**Application no: 23/03606/DISC**

**Location:** The Innovation Quarter, Bicester Heritage, Buckingham Road, Bicester, OX26 5HA

## **Transport Development Management**

Title
Phase 1 - Turning Area

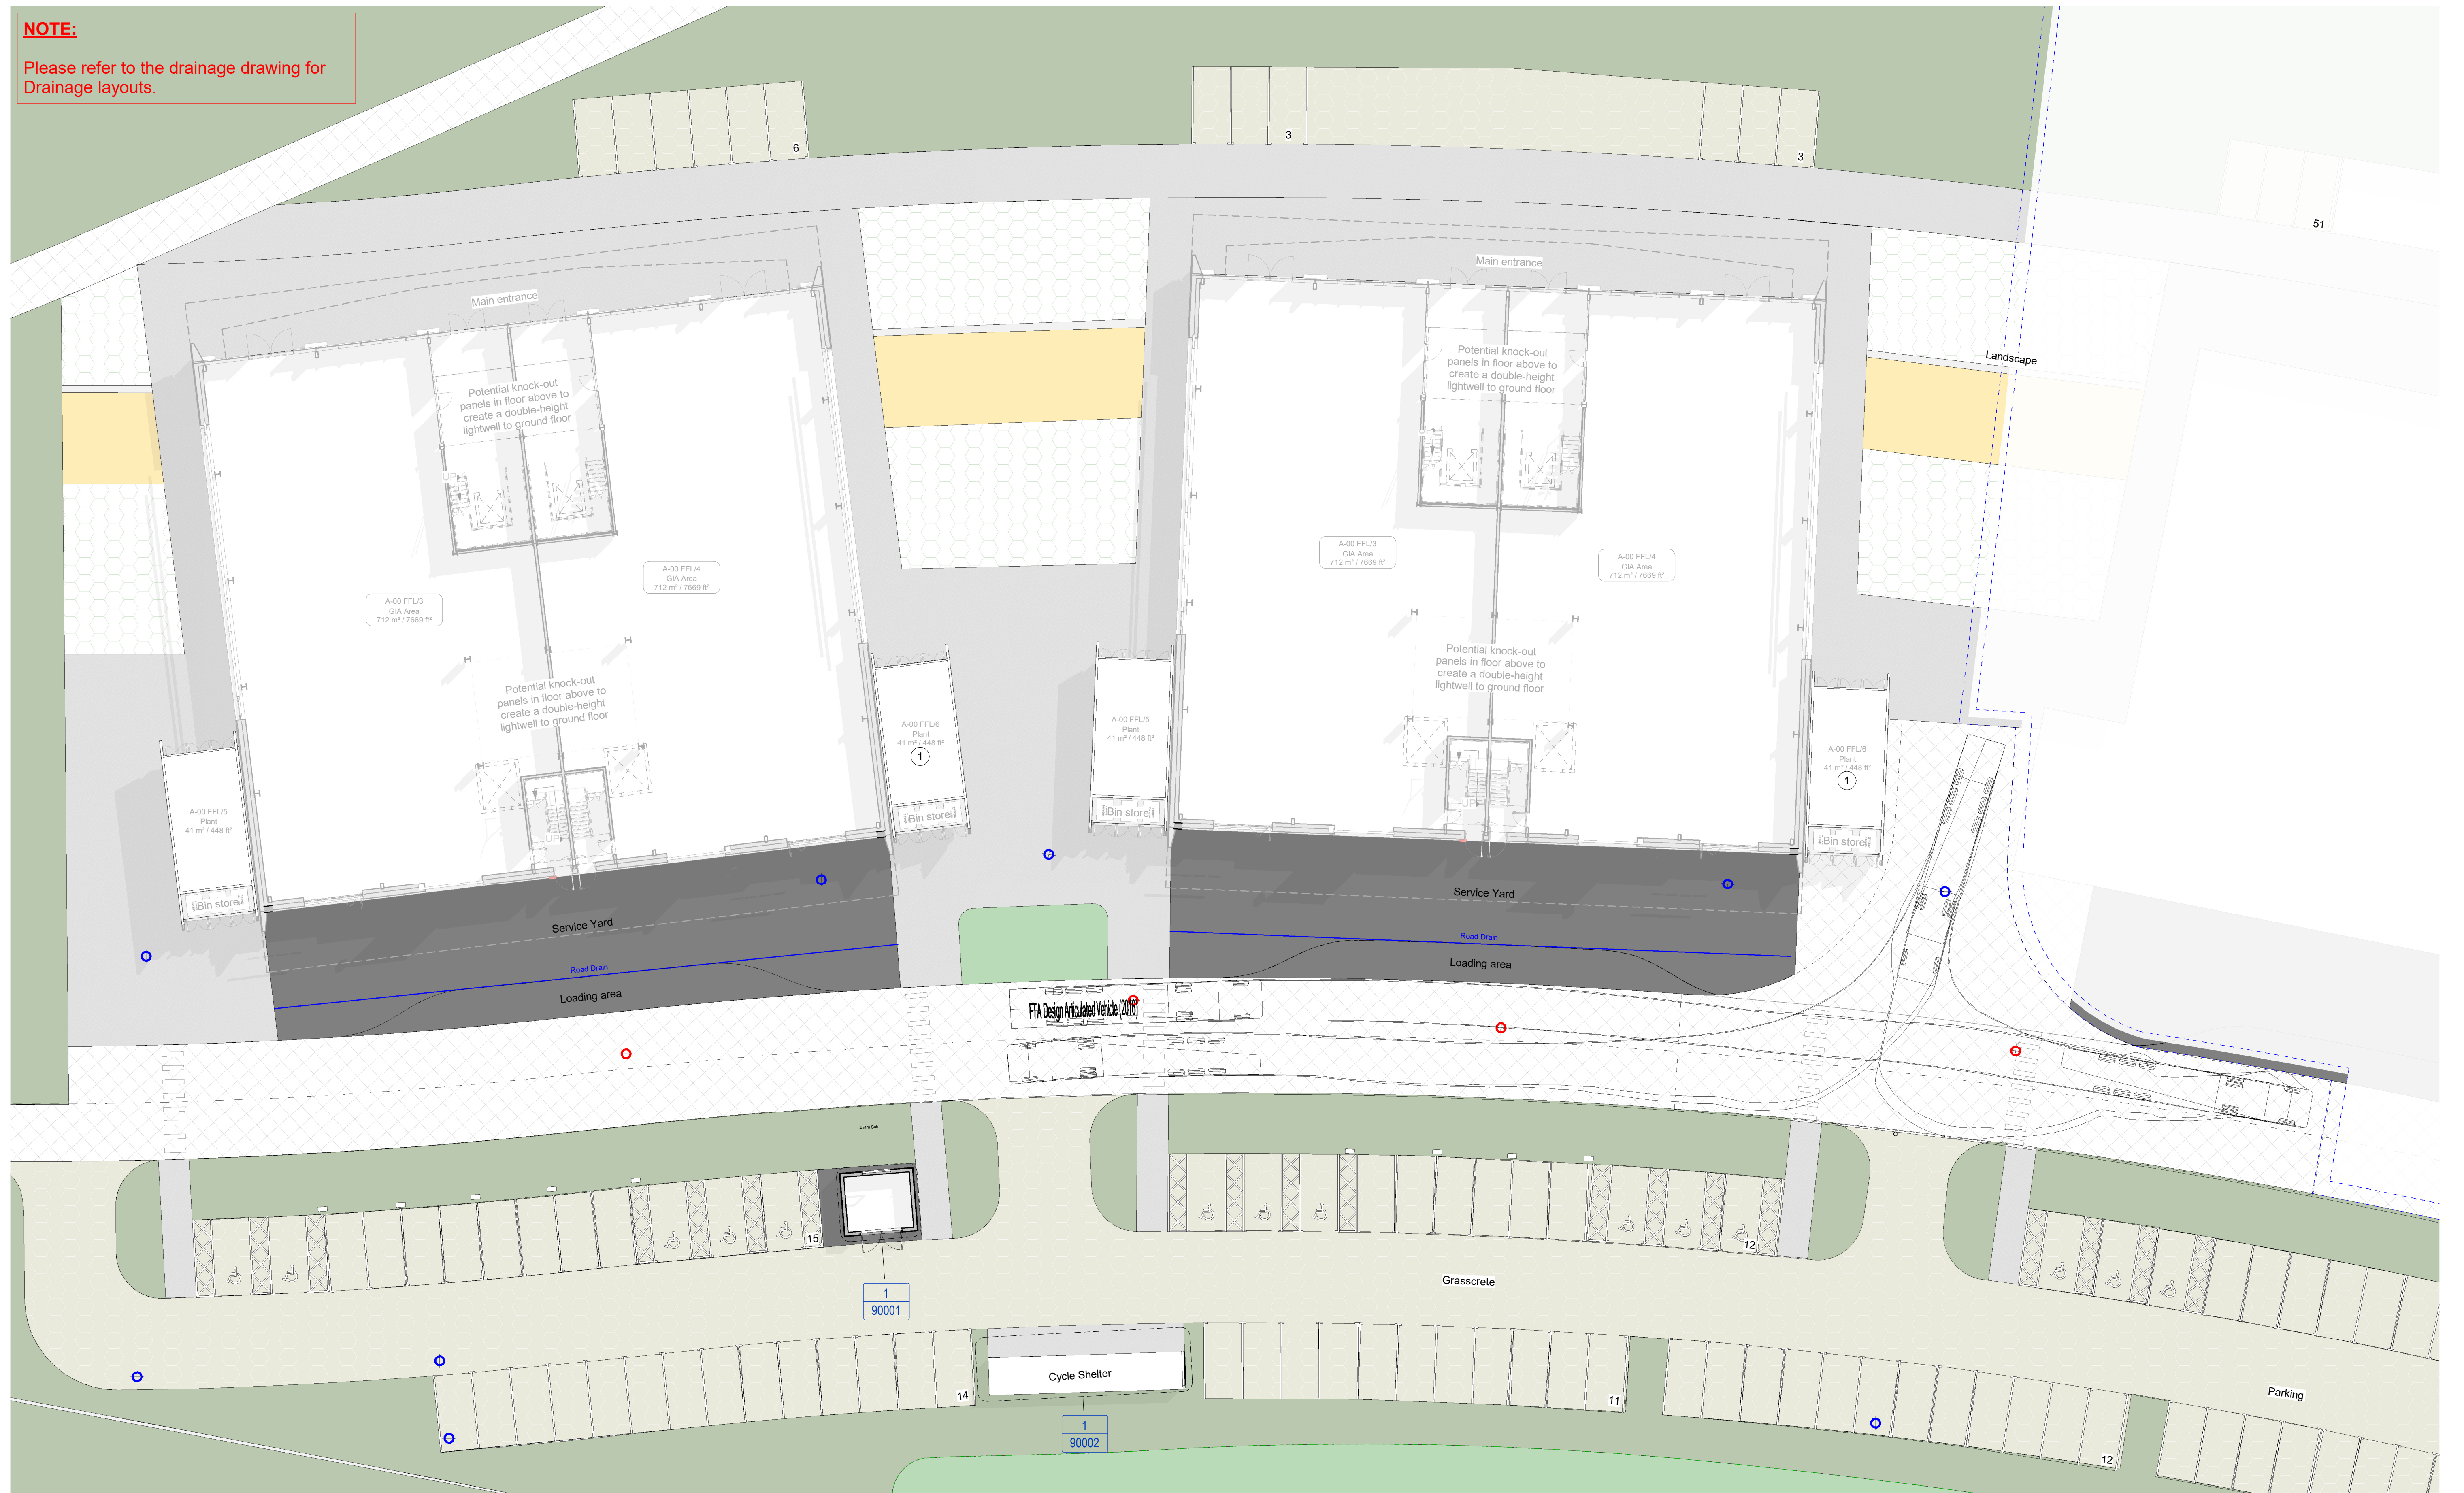
I consider the plans submitted to discharge this condition are appropriate.
